From: [REDACTED]
To: [Mona Offshore Wind Project](#)
Subject: EN010137
Date: 30 September 2024 22:35:57

IP ref: 20048555

Re ExQ1 Q1.8.2

Figure 1.3: Surface watercourses and NRW flood zones within the Mona hydrology and flood risk study area (sheet 1)

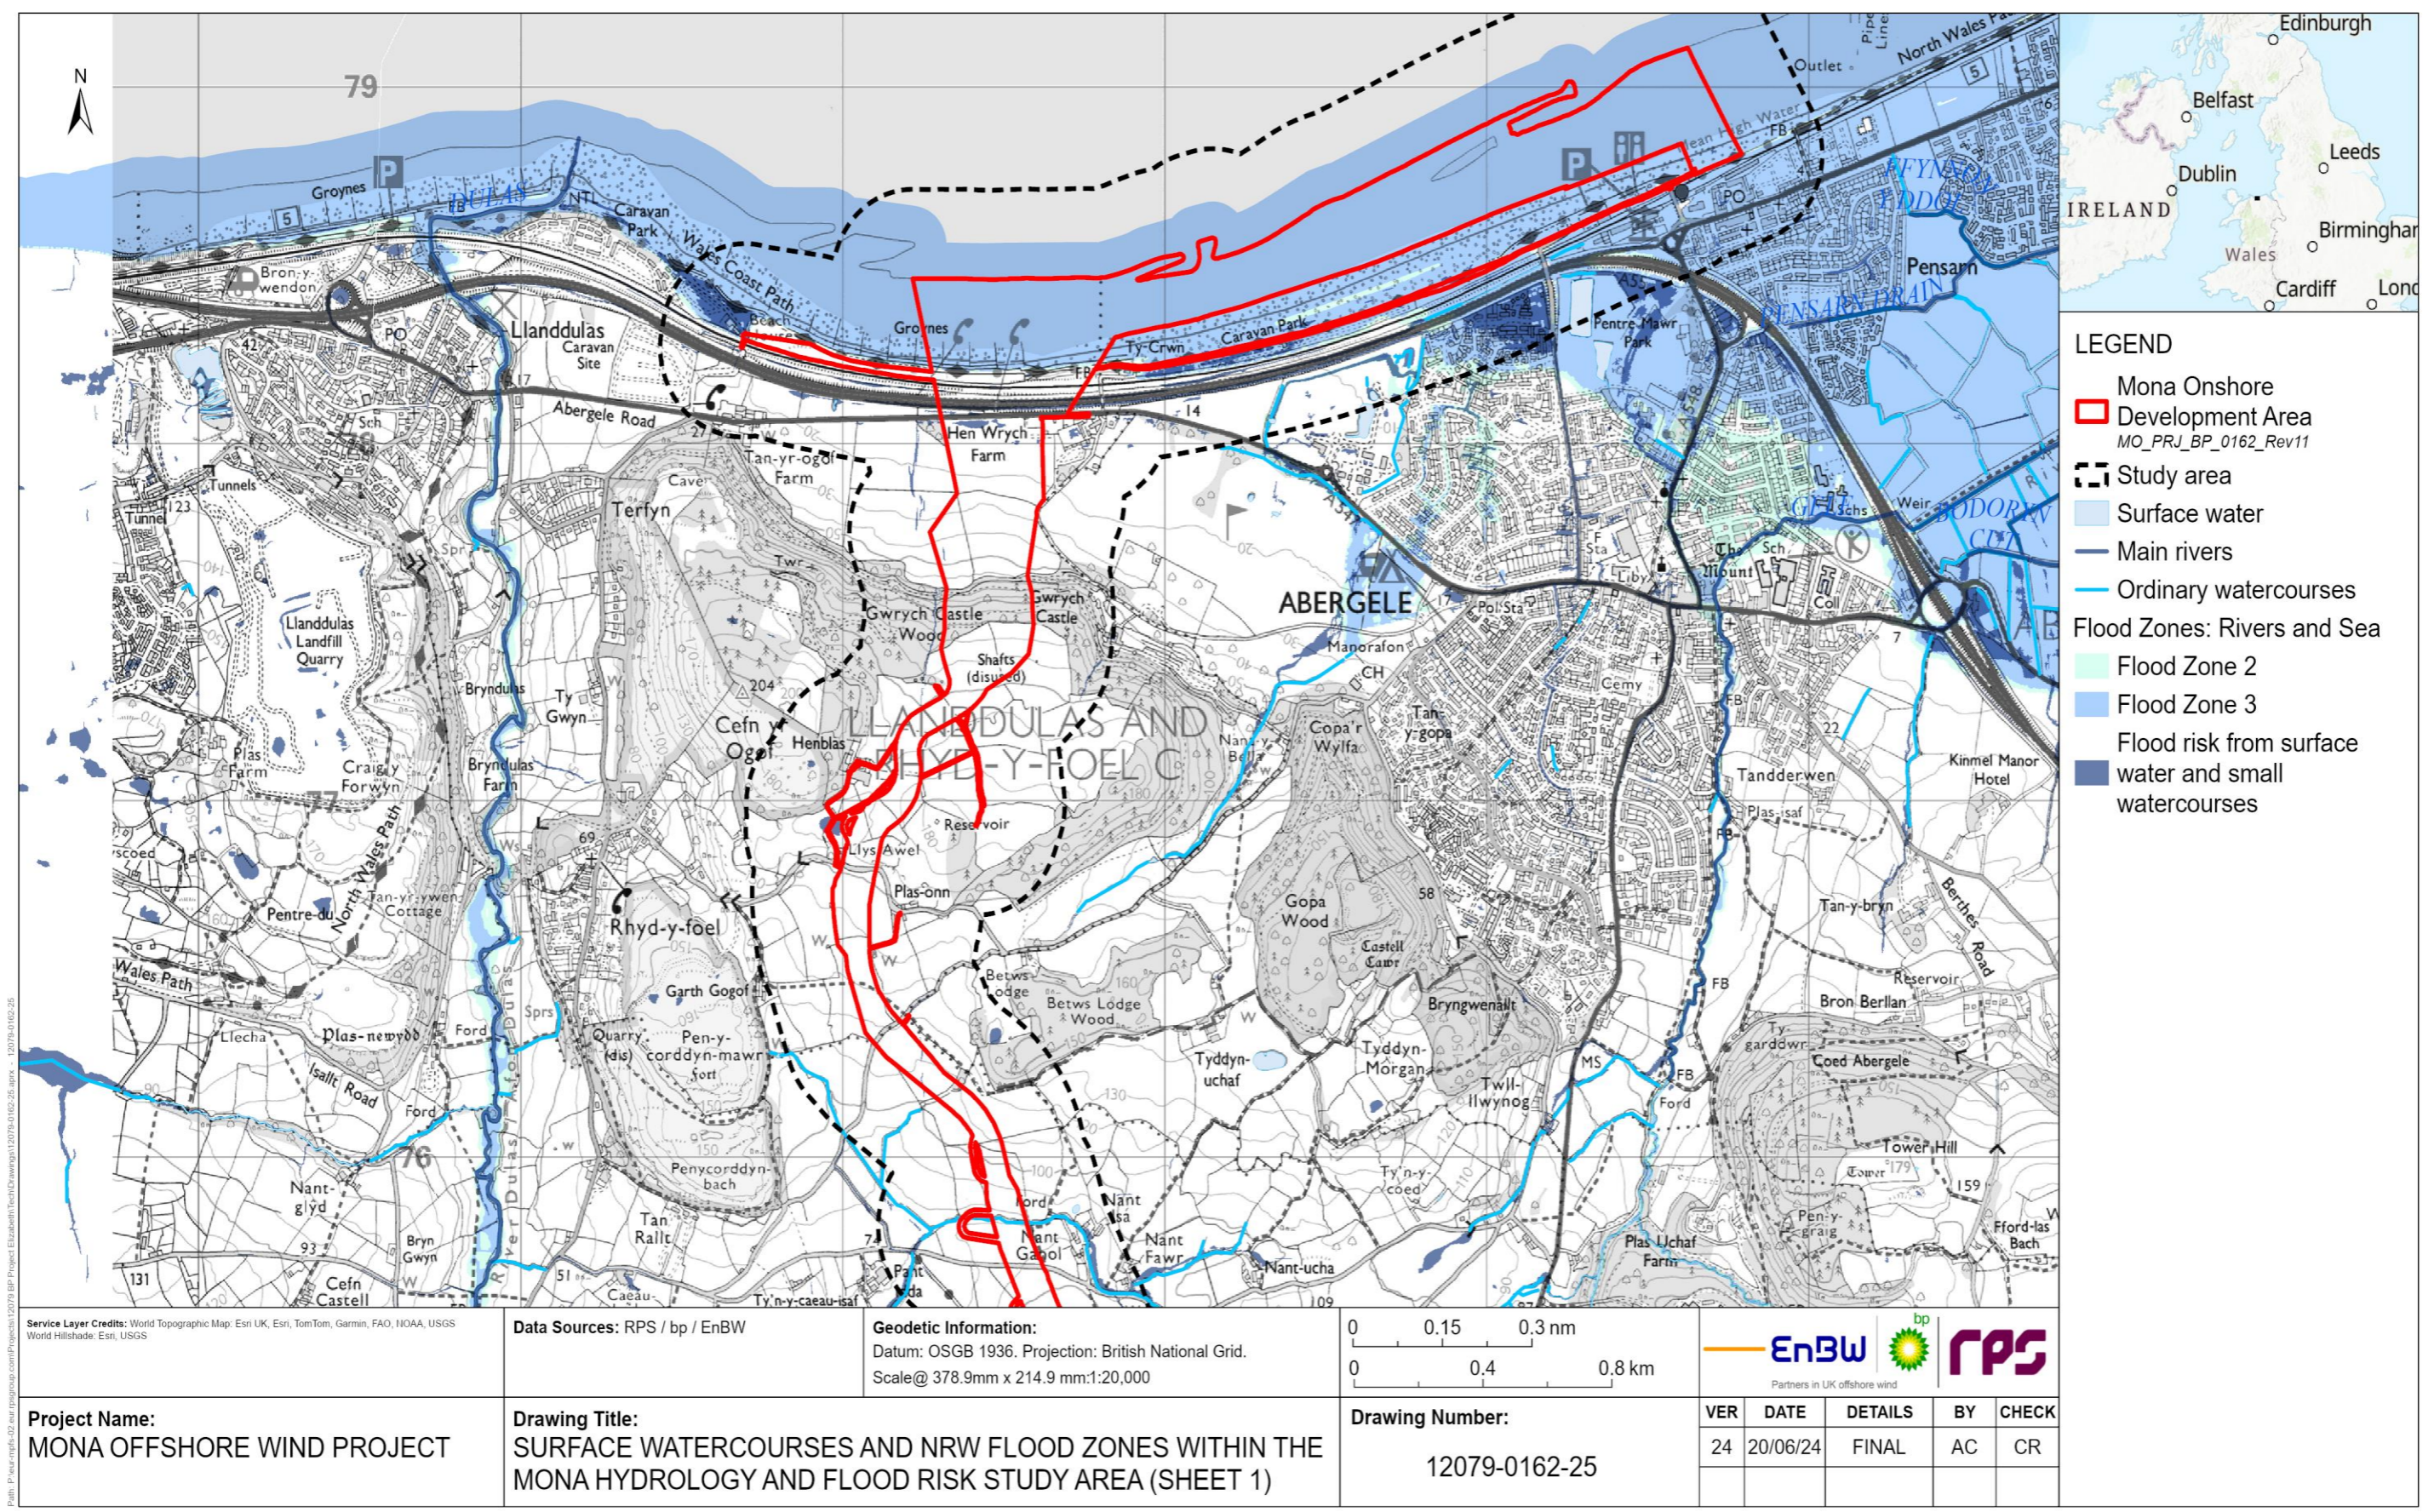
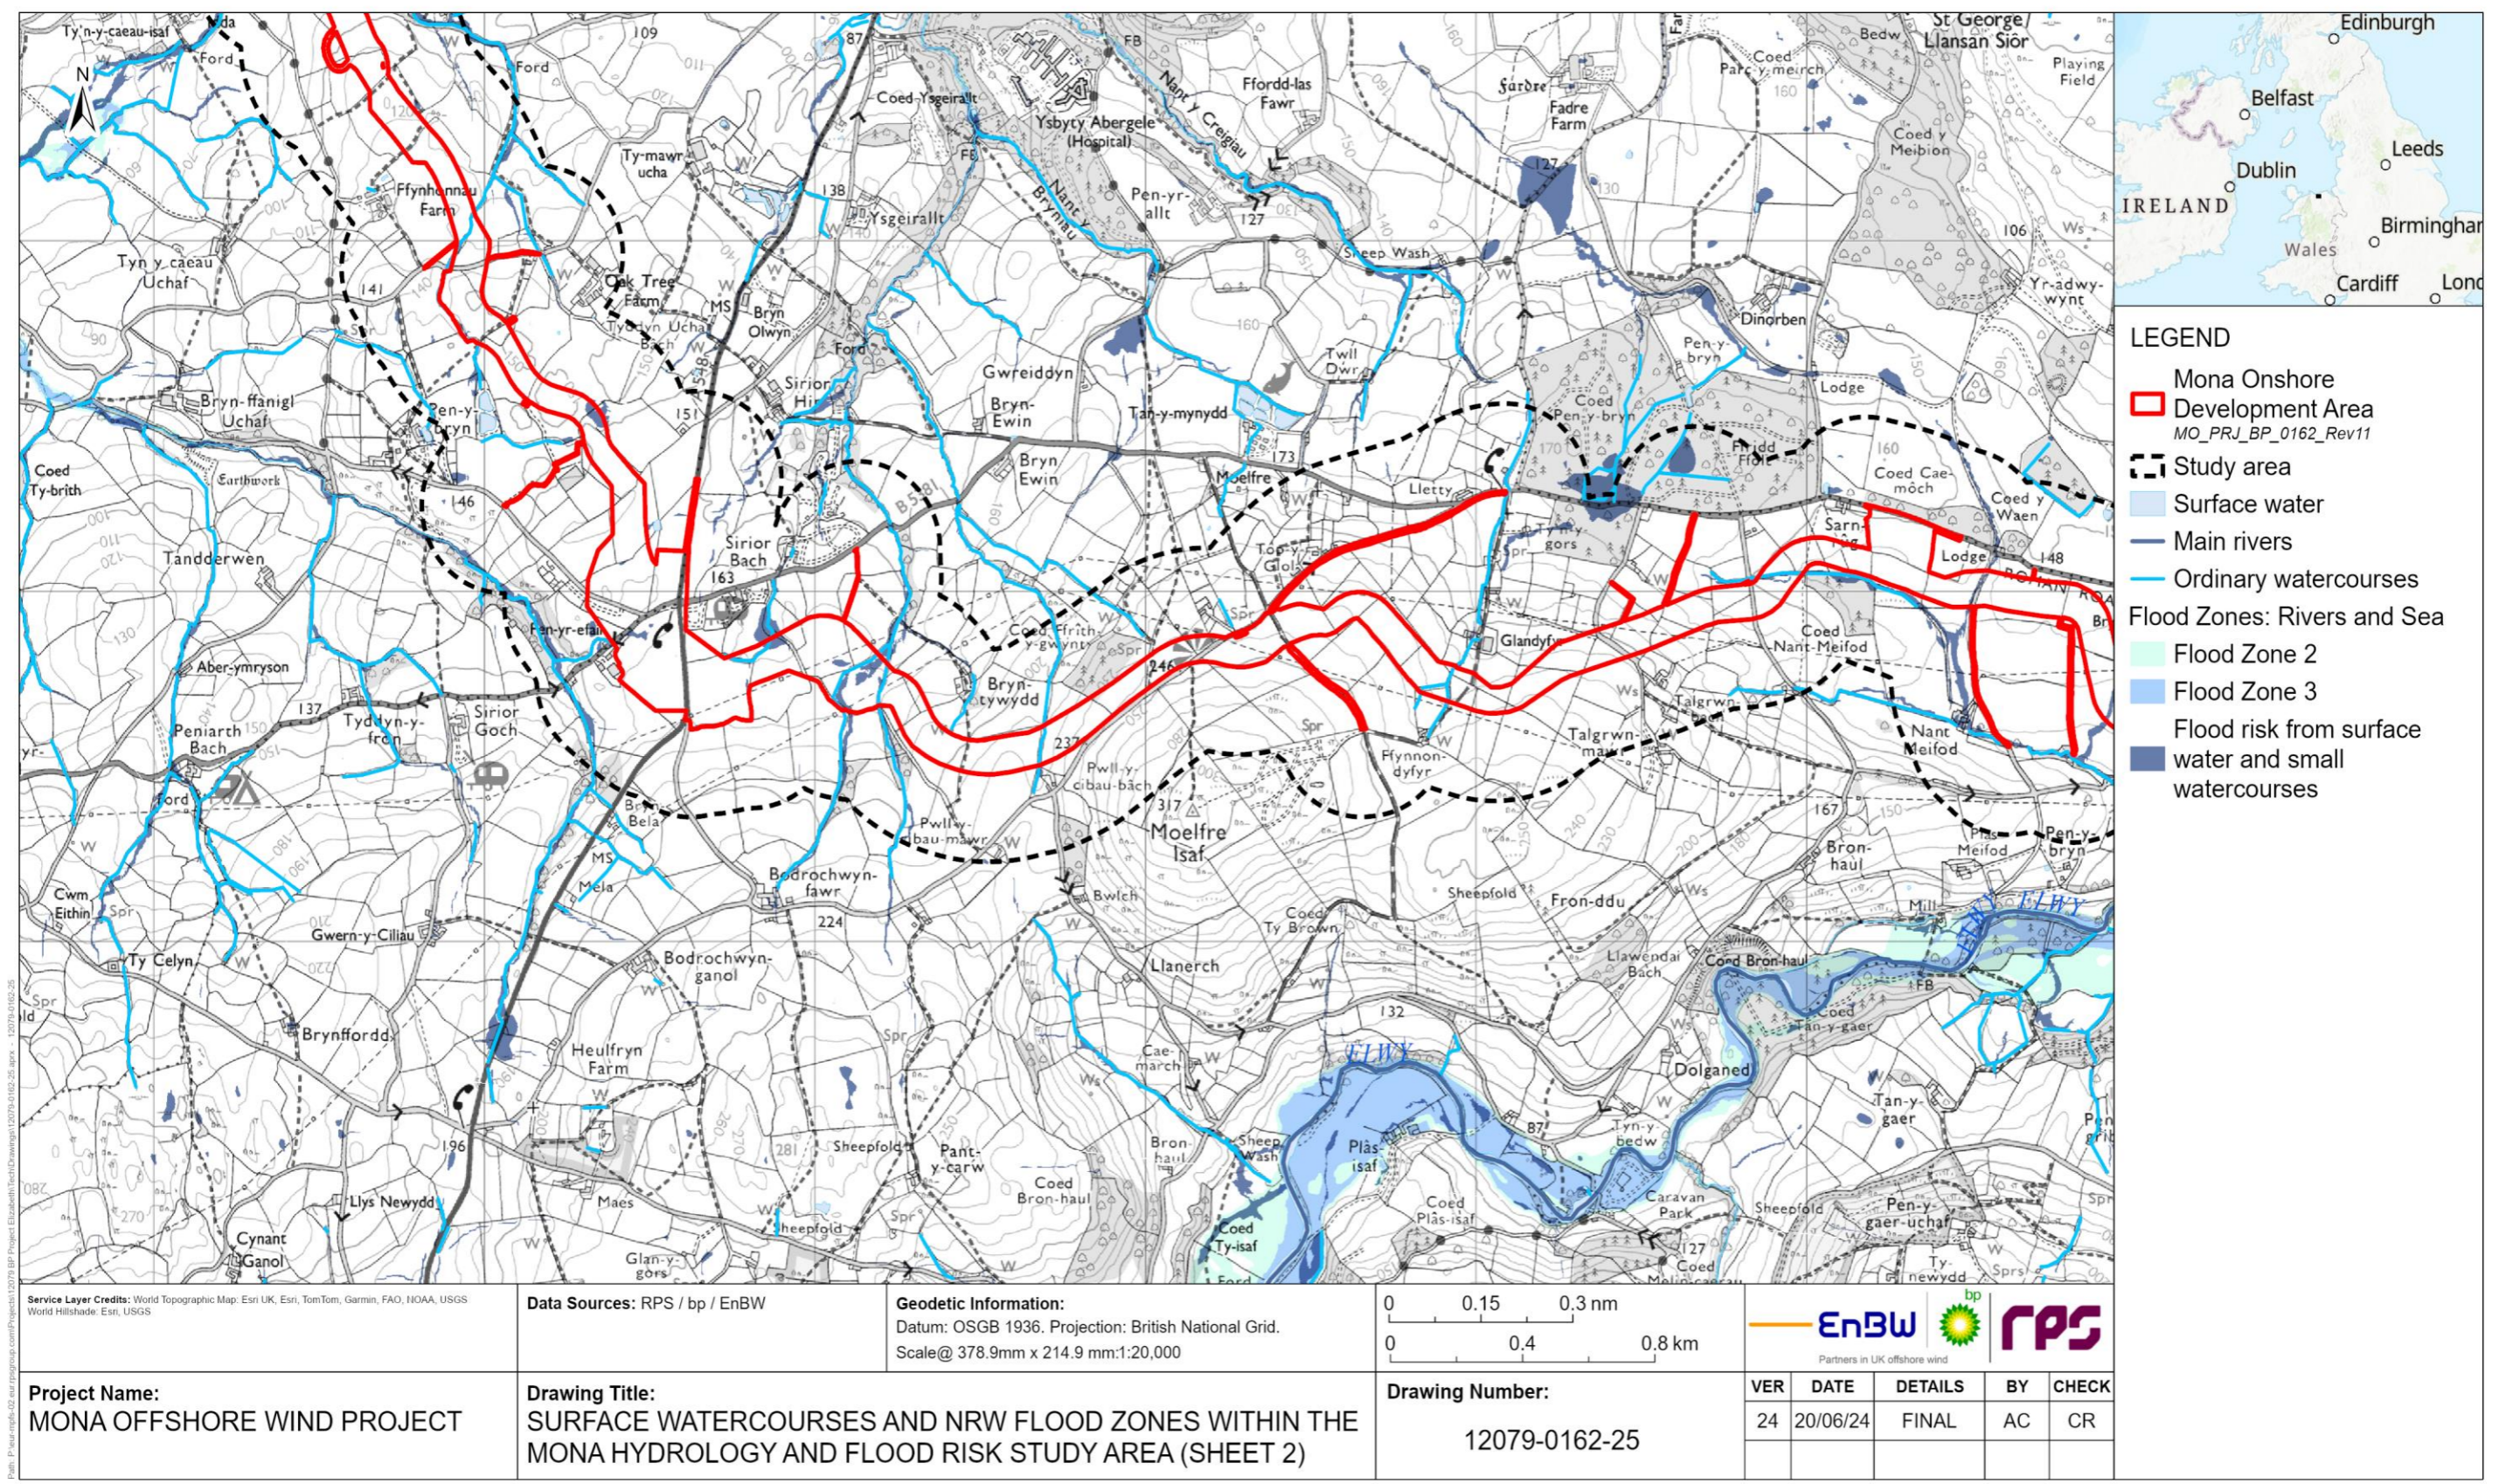
In answer to the exa's question regarding watercourses and flooding in the area of tcc2, has the applicant addressed my concerns? The answer is no.

The applicant's response has been to direct me back to their existing application documentation, which i have already made clear lacks any detail and has significant abnormalities, that makes looking at it again useless.

The document suggested makes no mention of the fact that if they are permitted to drill their cable where they sometimes say they want to (but at other points they indicate a different track) they will alter the location of the head of a river. It is impossible to predict the new location of a spring once its track has been disturbed at depth. The river issuing from the spring that i am talking about does not even feature on the applicants mapping. So their conclusion that damaging it will be negligible, when they don't even acknowledge its existence is baffling.
